From: [Ed Sewall](#)
To: [Jeremy Johnston](#); [Spencer Parr](#)
Cc: [Kelly Bacon \(CD\)](#); [Jeremy Larson](#)
Subject: RE: Swiftwater Storage CUP and Residential Building Application Parcel 15445
Date: Tuesday, May 25, 2021 11:17:02 AM
Attachments: [WLC Shoreline.png](#)

From: Jeremy Johnston <jeremy.johnston@co.kittitas.wa.us>
Sent: Tuesday, May 25, 2021 10:18 AM
To: Ed Sewall <esewall@sewallwc.com>; Spencer Parr <spencer@washingtonlawcenter.com>
Cc: Kelly Bacon (CD) <kelly.bacon.cd@co.kittitas.wa.us>; Jeremy Larson <jeremy.larson@co.kittitas.wa.us>
Subject: Swiftwater Storage CUP and Residential Building Application Parcel 15445

The Commercial Use being proposed under the Swiftwater CUP would be considered a High Intensity Use, which requires a 200 foot structural setback. We will need an updated site plan from the applicant which indicates these updated setback boundaries.

WLC PROPERTY HOLDINGS LLC
SITE PLAN

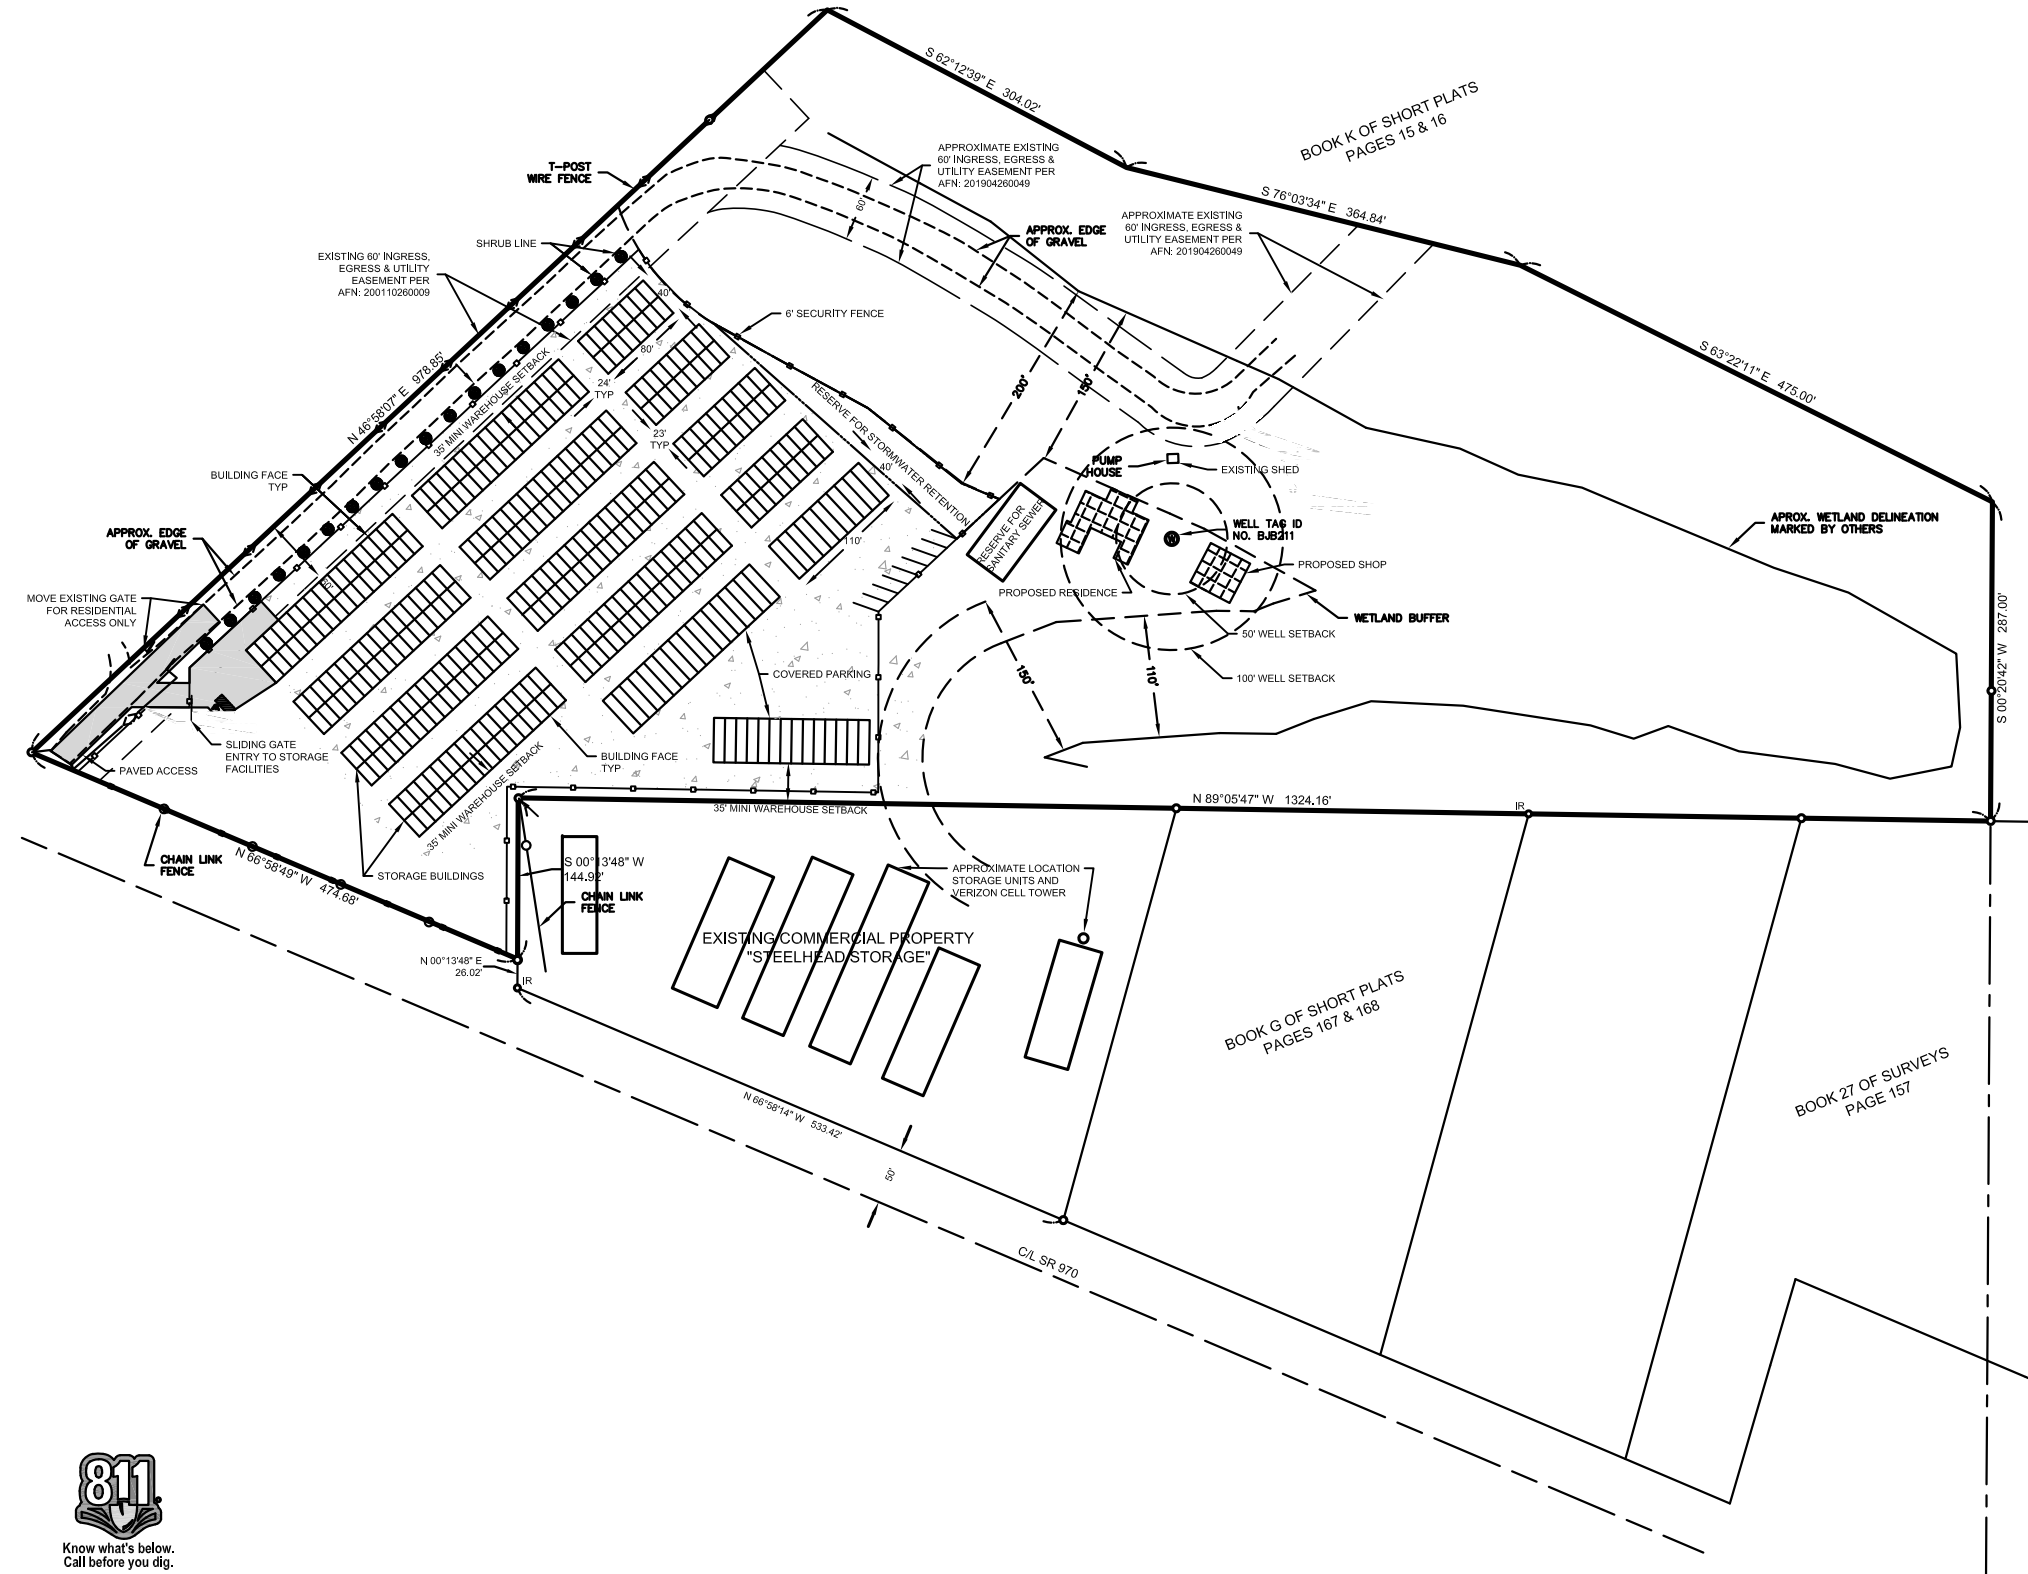
As a side note, regarding the proposed residence on the parcel, the site plan will need to be updated as well for this building application. In this case the residence is considered a moderate intensity use which will require a 150 foot structural setback (see table above). Depending on the precise location

WLC PROPERTY HOLDINGS LLC
SITE PLAN

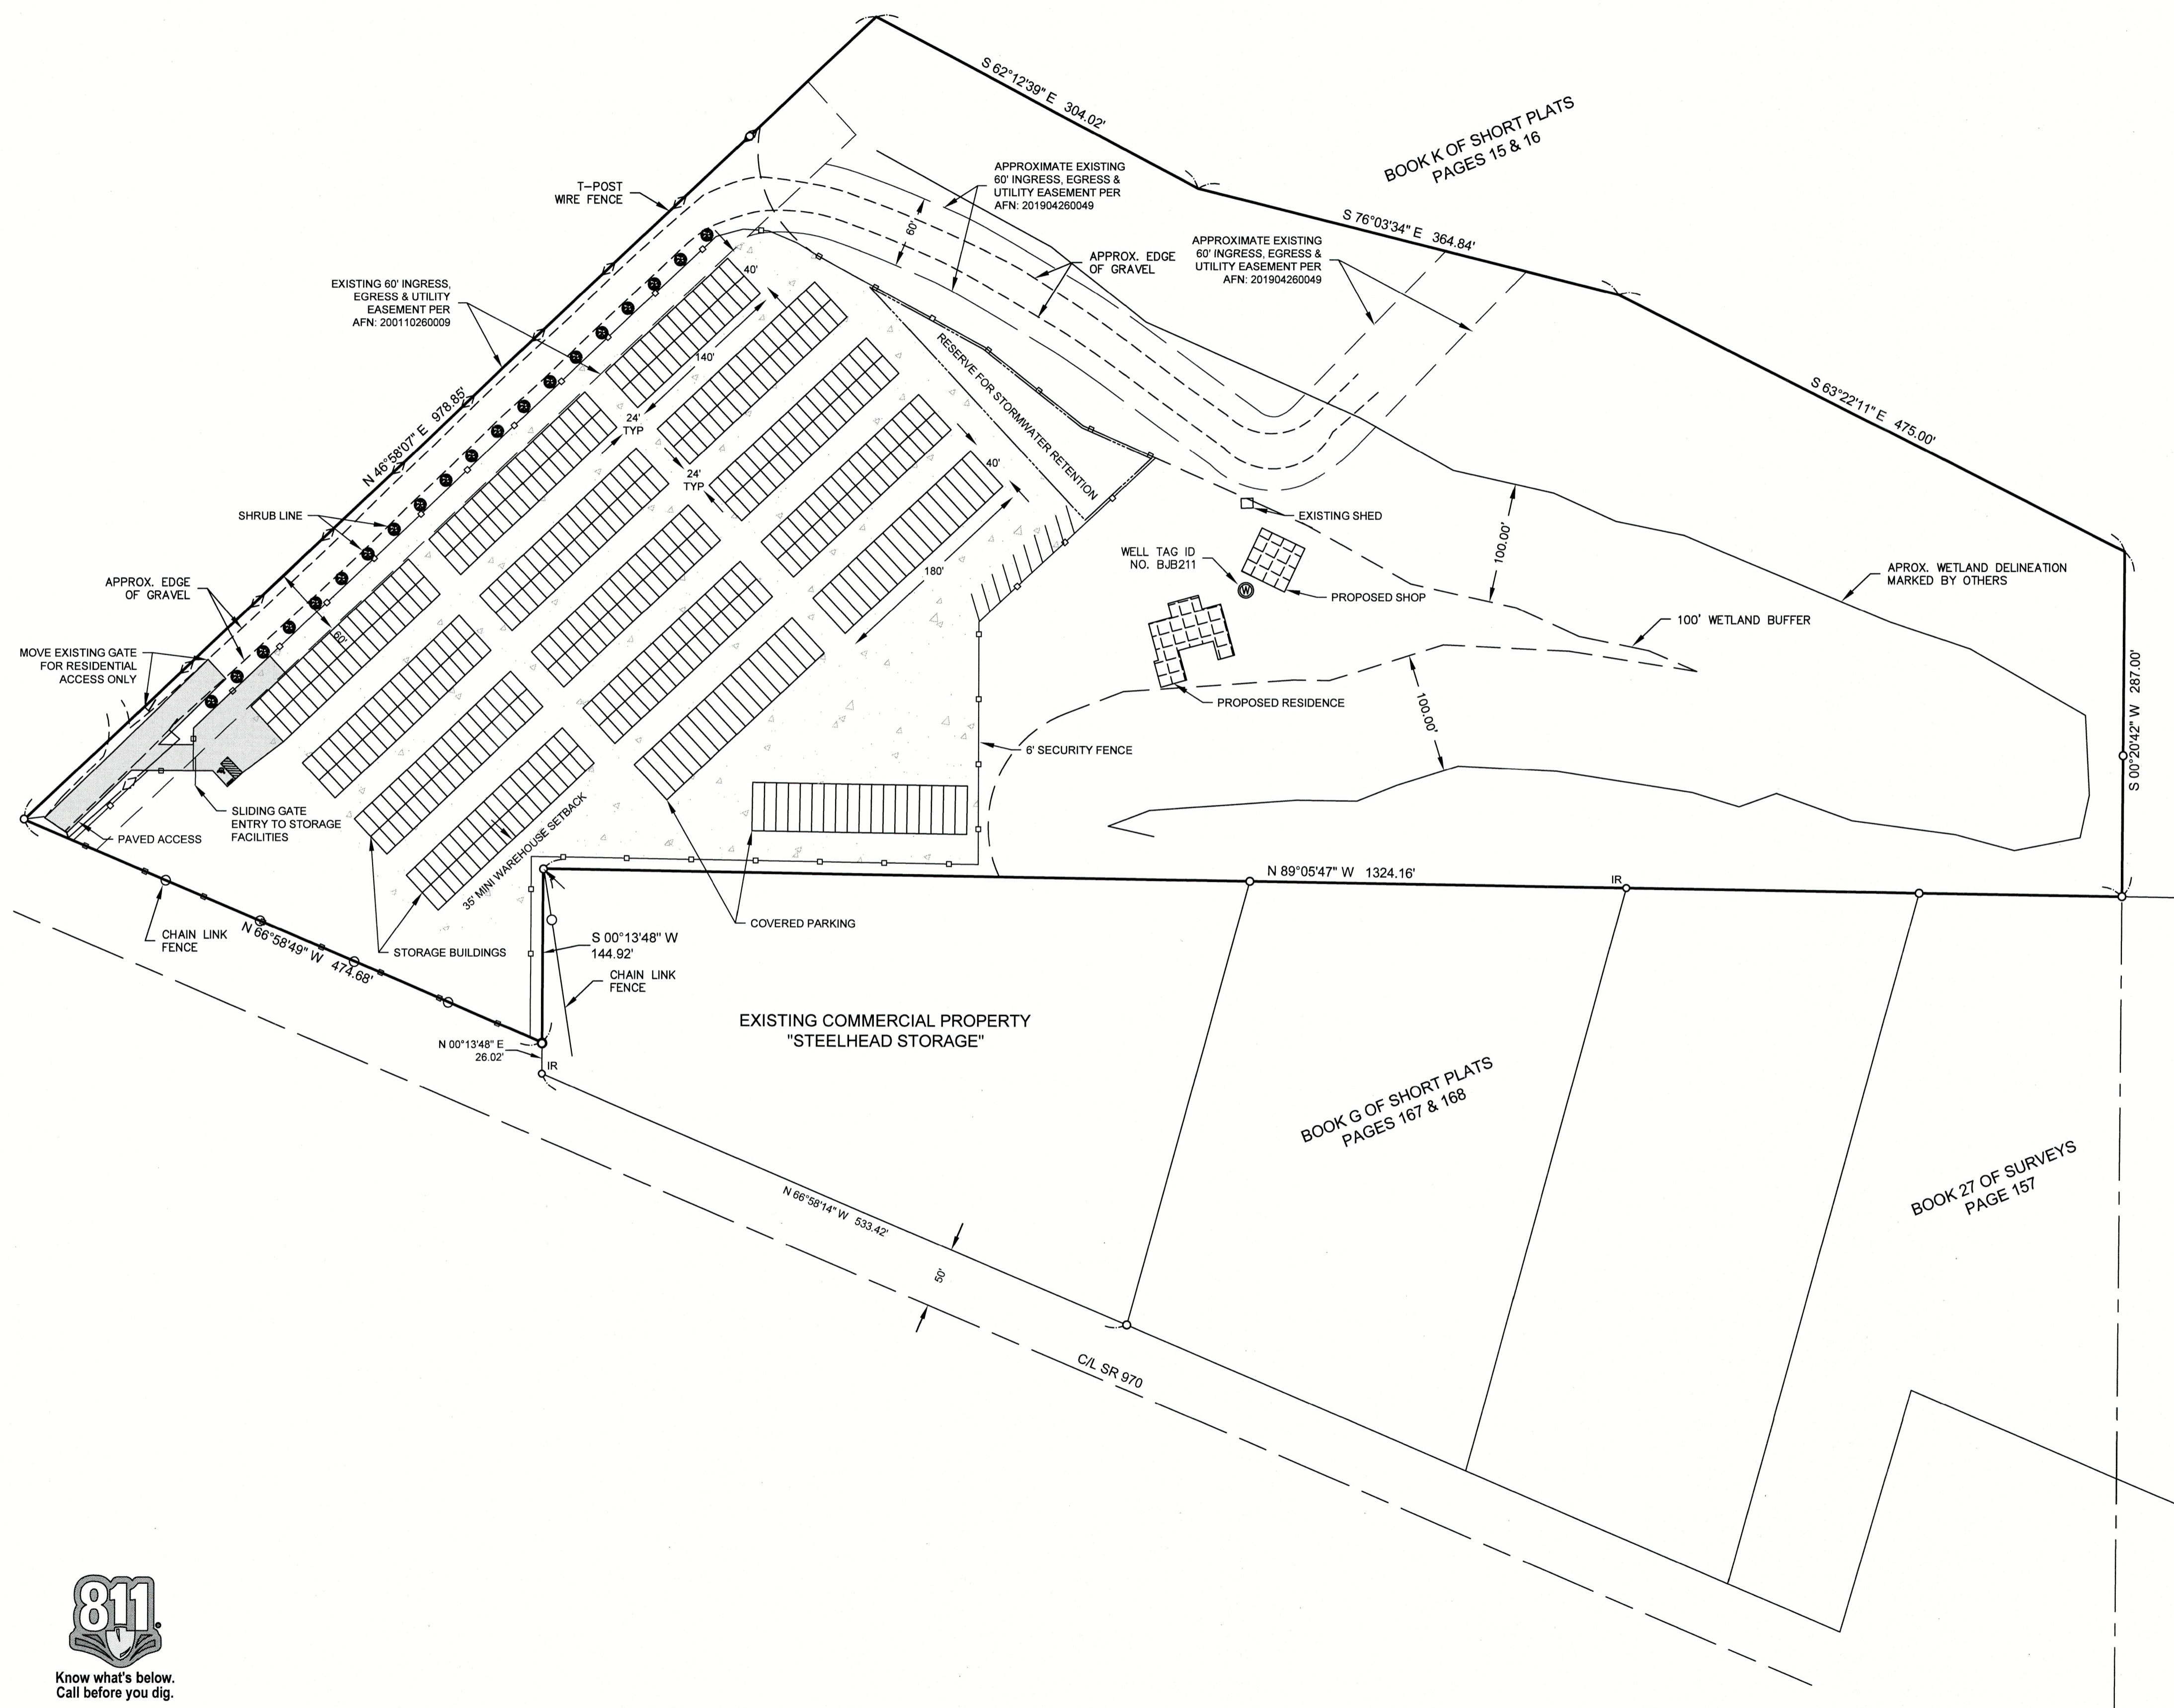
Thank you for the clarification, this is helpful. I do have to note that these wetland areas are considered contiguous to a Shoreline and therefore the buffers must be drawn from KCC 17B.50.020G-1, For Category 2 wetlands. These buffers are as follows:

Please provide the updated site plan for the Swiftwater CUP to Kelly Bacon (CC'd) in this email. The updated site plan for the residence can be sent to myself and Jeremy Larson in CDS Building (Also CC'd in this email). Once I am able to review the updated residential site plan I will let you know whether a Shoreline Exemption is necessary.
